Our Ref: STH10/00063/08
Contact: Chris Millet (4221 2570)
Your Ref: MP09_0088

**SHOALHAVEN CITY COUNCIL – MAJOR PROJECT 09_0088 – MIXED USE SUBDIVISION,
WEST CULBURRA**

Reference is made to your email dated 24 April 2014 regarding the subject project application forwarded to Roads and Maritime Services (RMS) for consideration.

Liability limited by a
scheme approved
under Professional
Standards Legislation

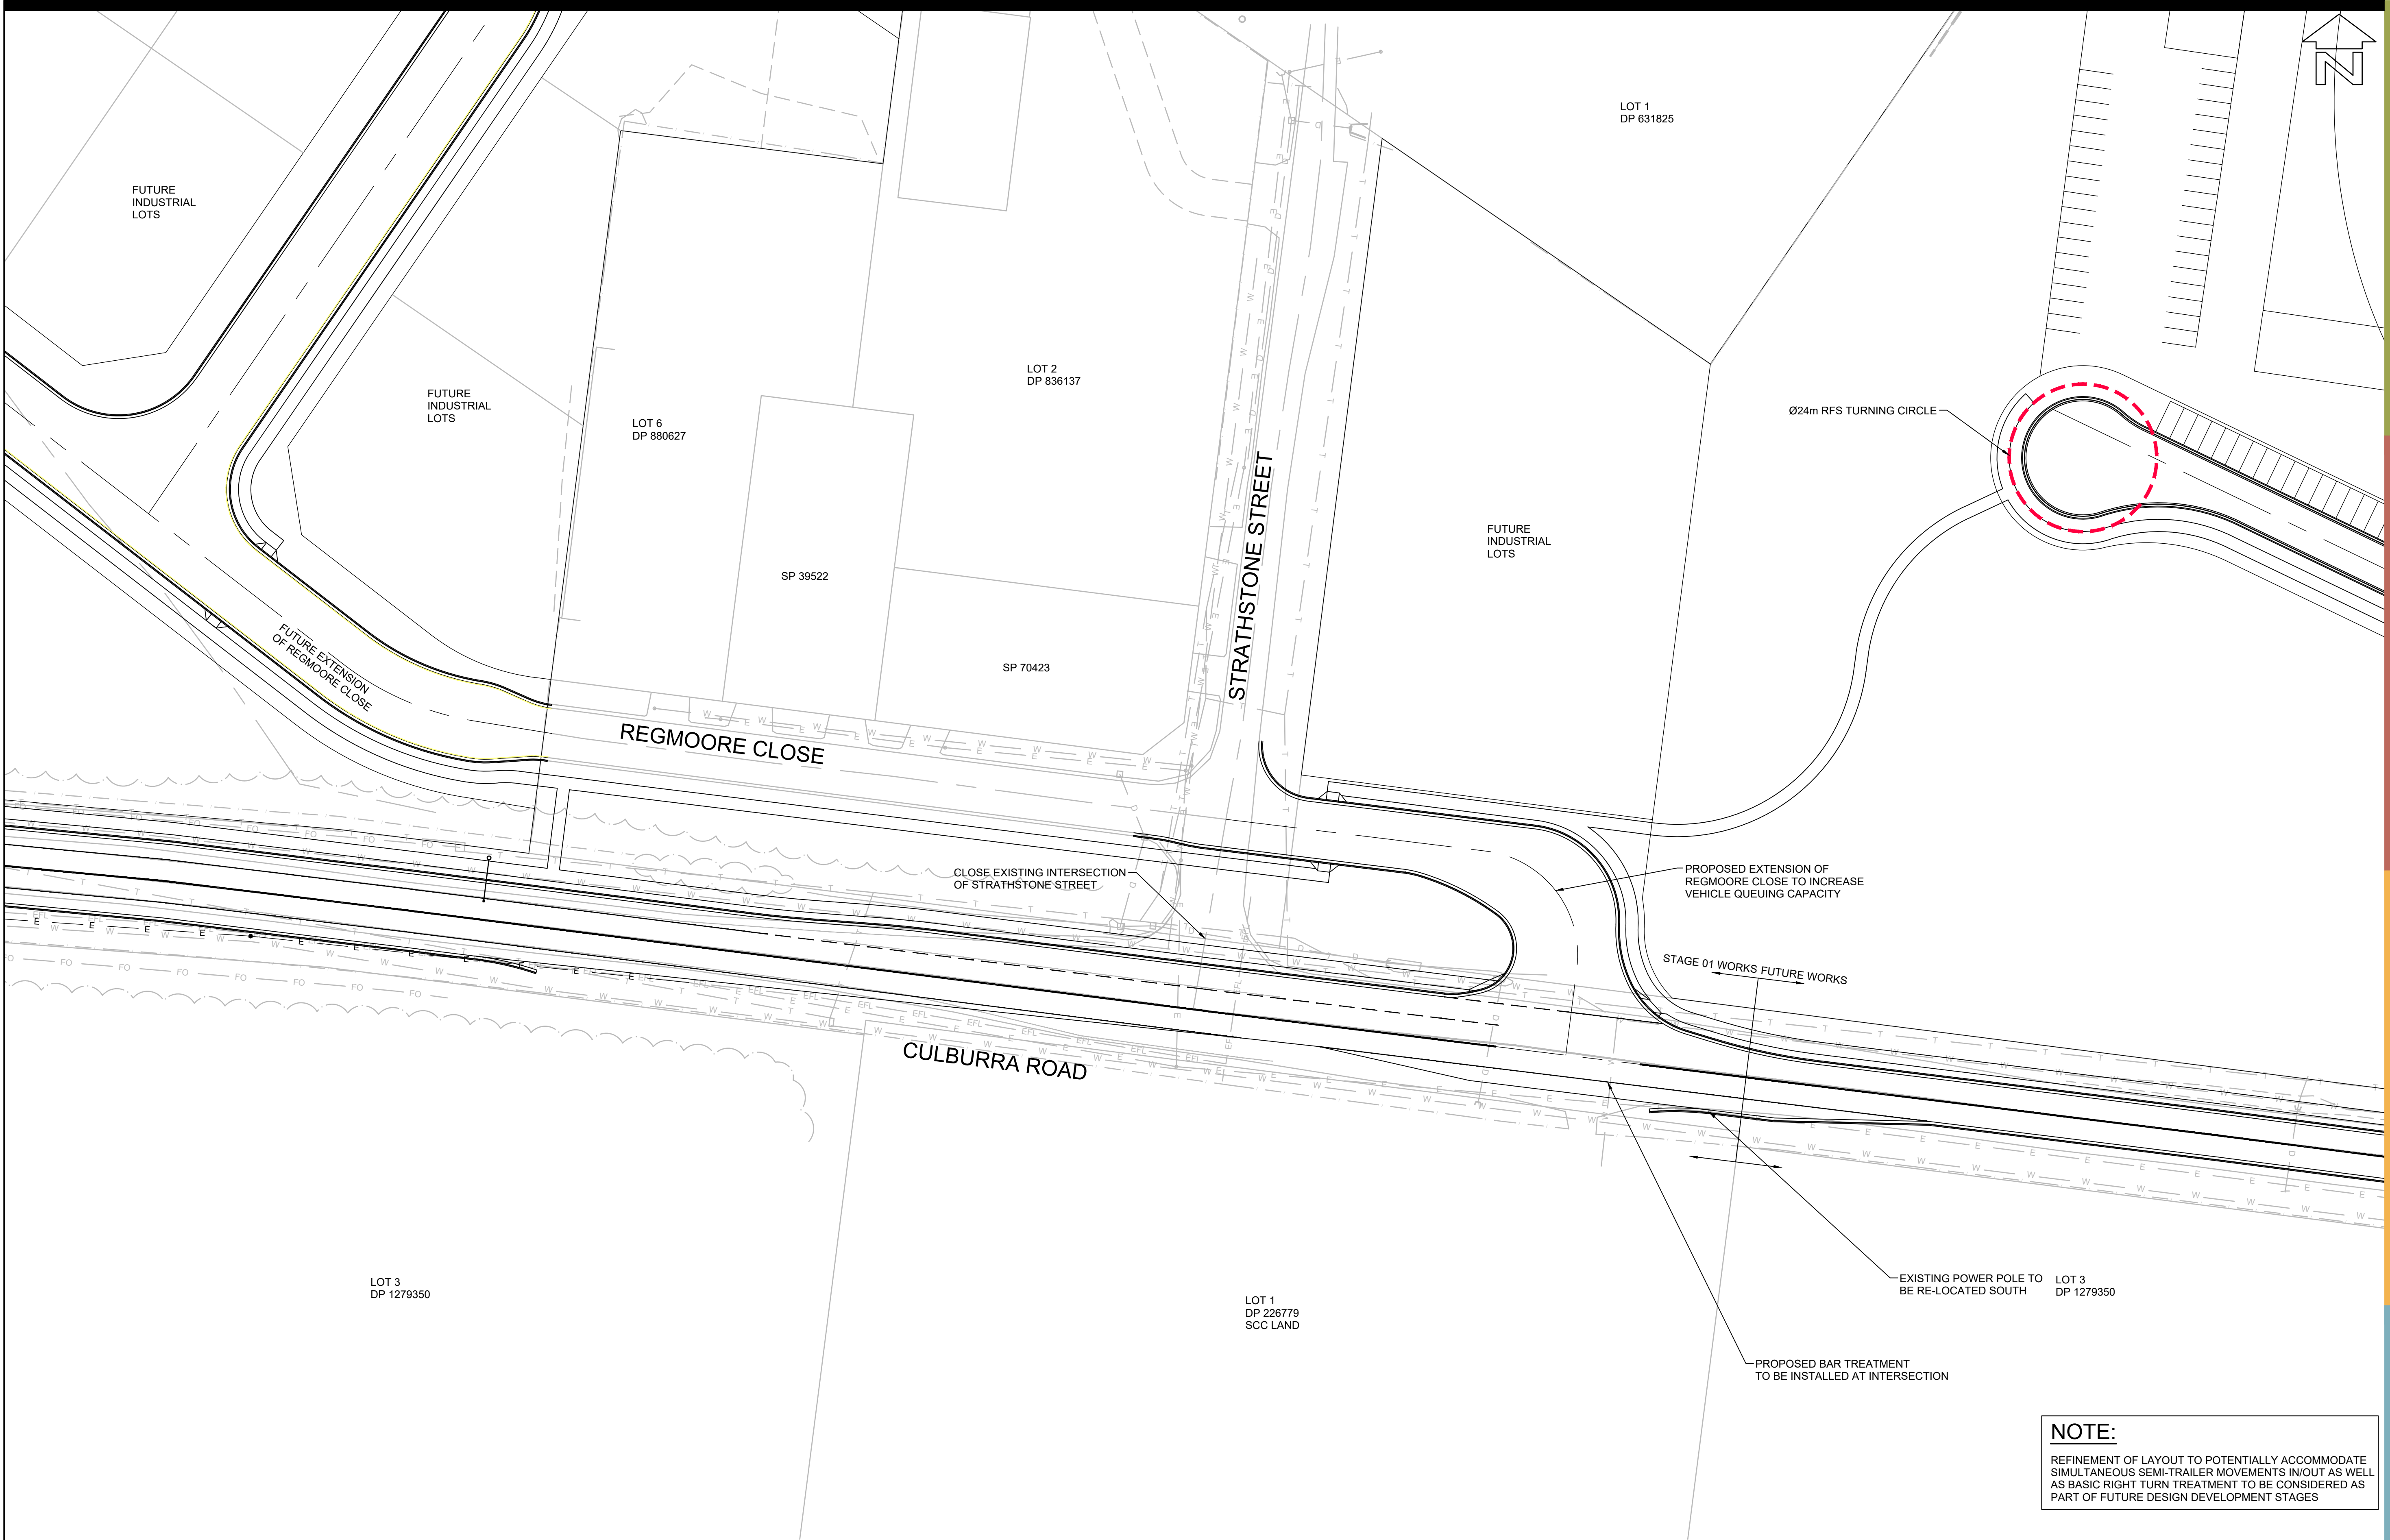
- The proponent providing a design which demonstrates that appropriate sight distance will be available to roundabout prior to determination of the project. Given that the roundabout will be located immediately after the transition from the 100km/h speed zone, RMS considers that the design speed for sight distances needs to be 10km/h above the intended posted limit. Therefore sight distance will need to comply with Austroads standards for a 90km/h speed environment. This includes appropriate sight distance to the layout of the roundabout for both eastbound and westbound vehicles. The location of the roundabout and demonstration of compliance with sight distance requirements would need to be based on survey and design.
